A/7/26/L

Elm Grove Cottage The Square Angmering BN16 4EA

Listed building consent for the replacement of two windows on the ground floor at the rear of the house

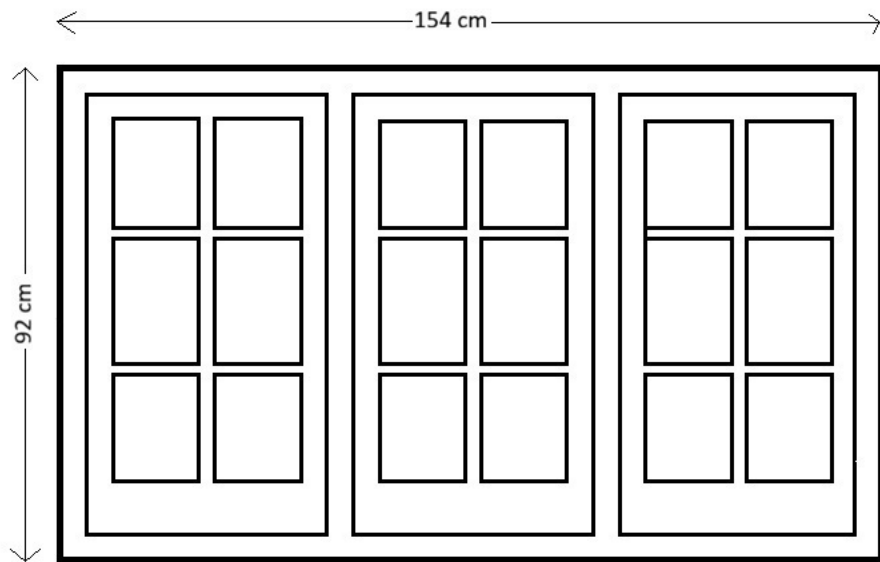
The existing windows do not appear to be of historic significance, and there is potential to replace them with windows incorporating heritage-style double glazing. However, the level of information submitted is minimal, making it difficult to assess the proposal's full impact. There is no detail regarding the glazing specification, specifically whether the units will be standard 28 mm or a slimmer heritage-type profile. As you are aware, standard 28 mm glazing units would not be acceptable.

Where windows incorporate glazing bars, these traditionally form part of the structural frame. Applied (non-structural) glazing bars are historically inaccurate and visually unconvincing. The plans do not make clear whether the proposed glazing bars are integral or applied, and this needs clarification, as applied bars would not be supported.

At present, the information provided is insufficient to assess the impact of the proposed works. Further details are required, including glazing specifications and confirmation of whether glazing bars are integral or applied.
